# Modification of Development Consent

Section 4.55(1A) of the *Environmental Planning and Assessment Act 1979*

| <b>For the following:</b>   | Construction and operation of Stage 2 of the redevelopment of Campbelltown Hospital involving the demolition of existing structures, construction of a new 13 storey clinical services building with rooftop helipad, a new multi-storey connection (hospital spine) between the main hospital buildings and associated works including alterations to access and parking, tree removal and landscaping. |
| <b>Modification:</b>        | <b>SSD-9241-MOD-3:</b> Amend Condition B20(e) to repurpose redundant traffic lane to a breakdown shoulder.   |

2 PLAN - PROPOSED ROADWORK - APPIN ROAD
1 : 1000

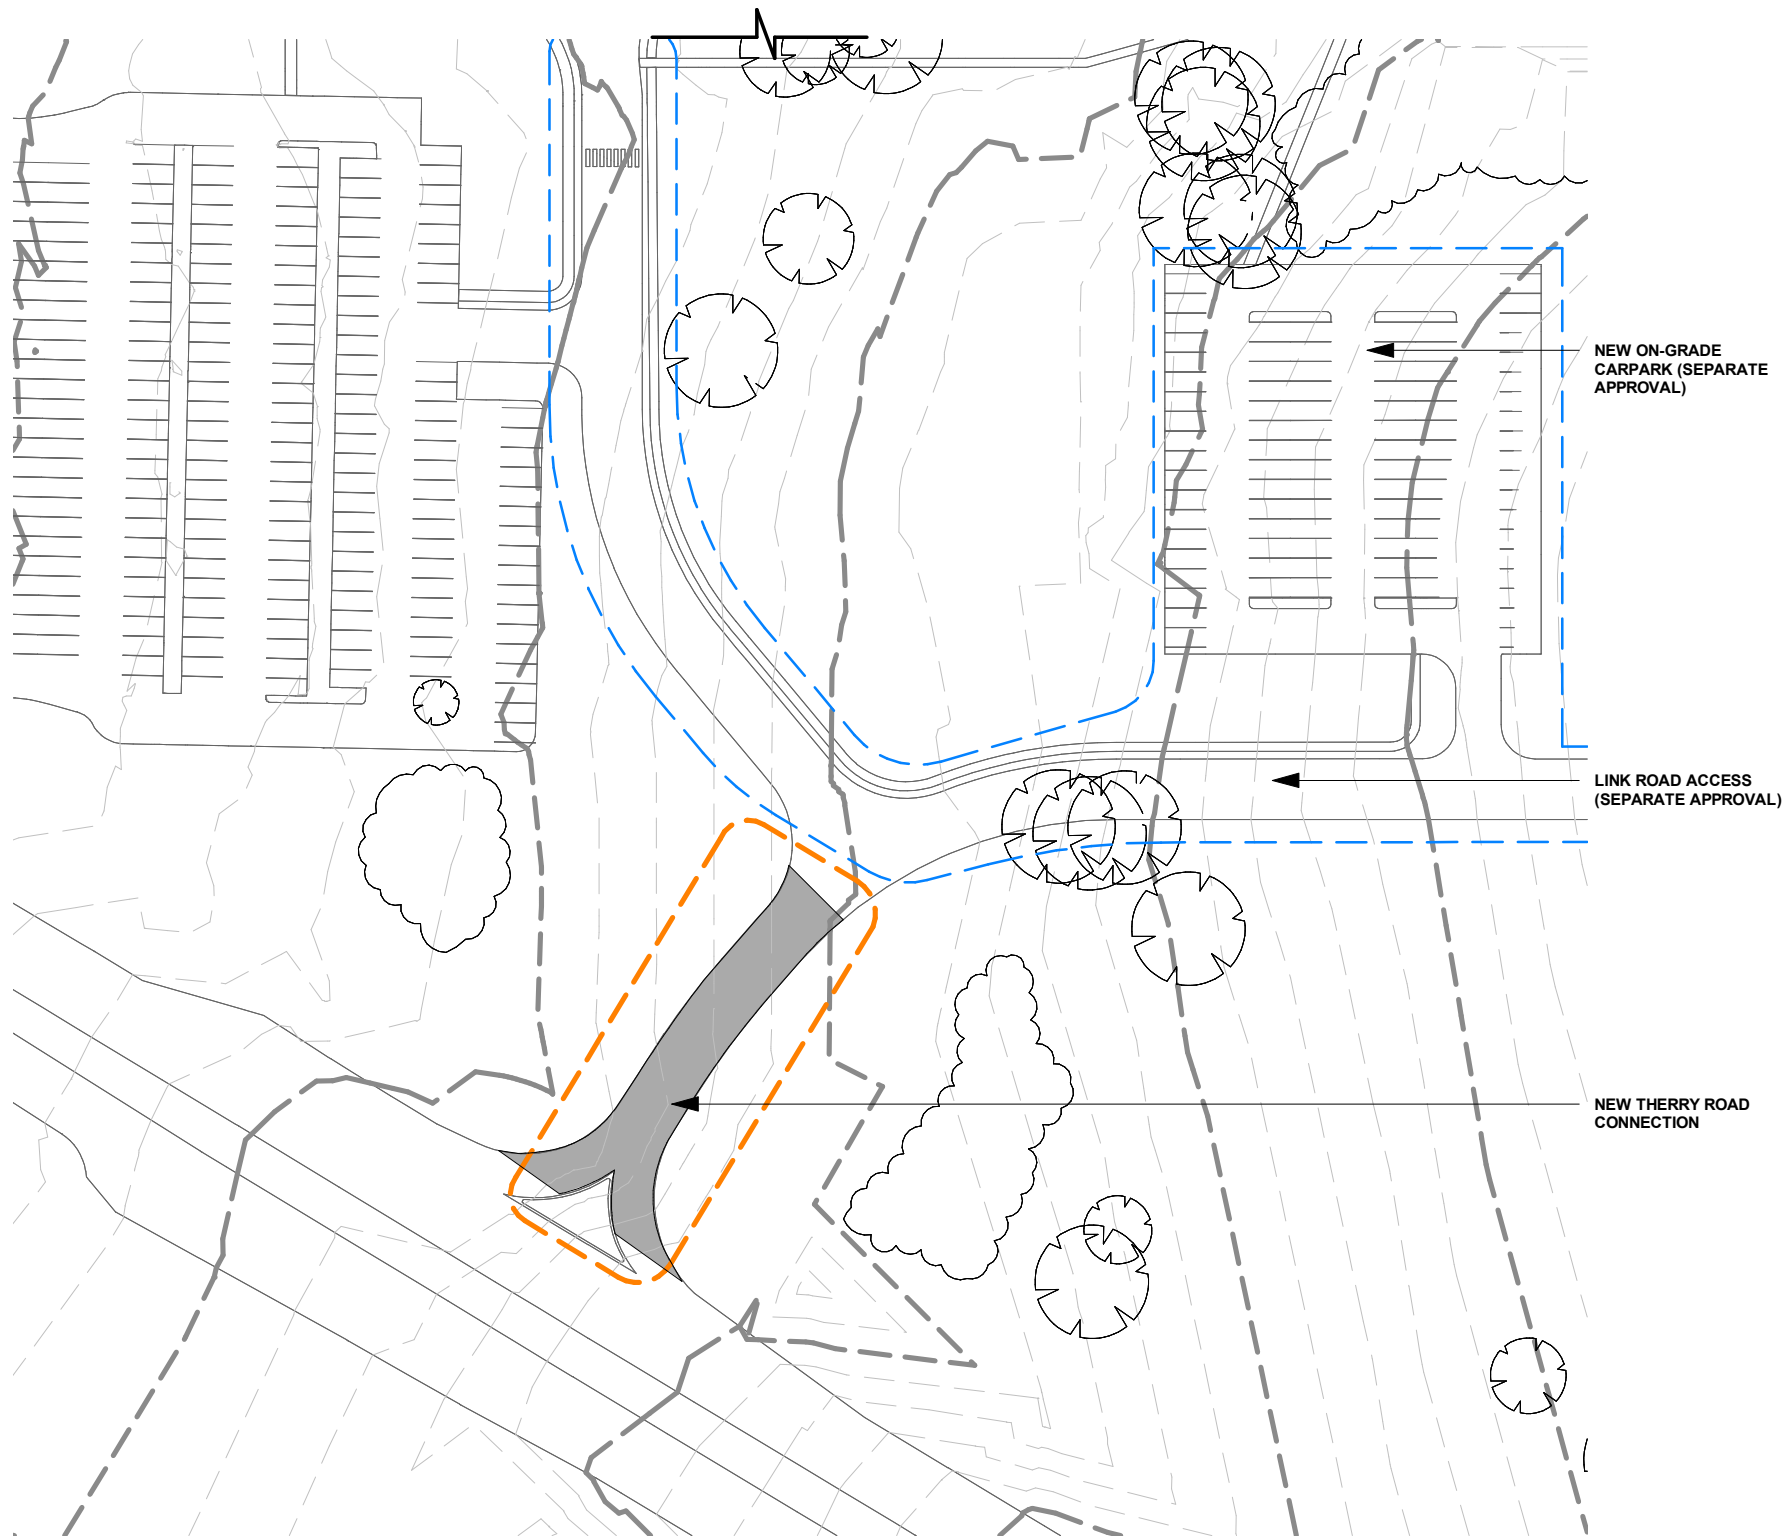
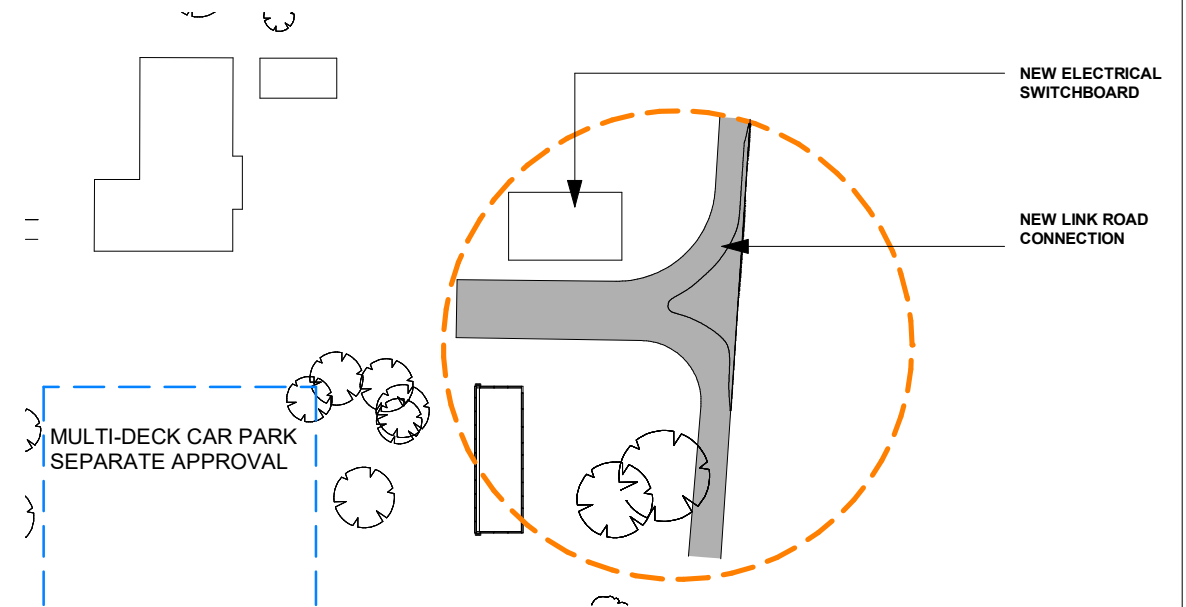
- (e) ~~The Applicant must carry out works to remove the existing deceleration lane and vehicular crossing to Appin Road at no cost to RMS.~~ **The Applicant must carry out works to remove the existing vehicular crossing to Appin Road and repurpose the deceleration lane into an emergency breakdown shoulder at no cost to Transport for NSW (RMS).**
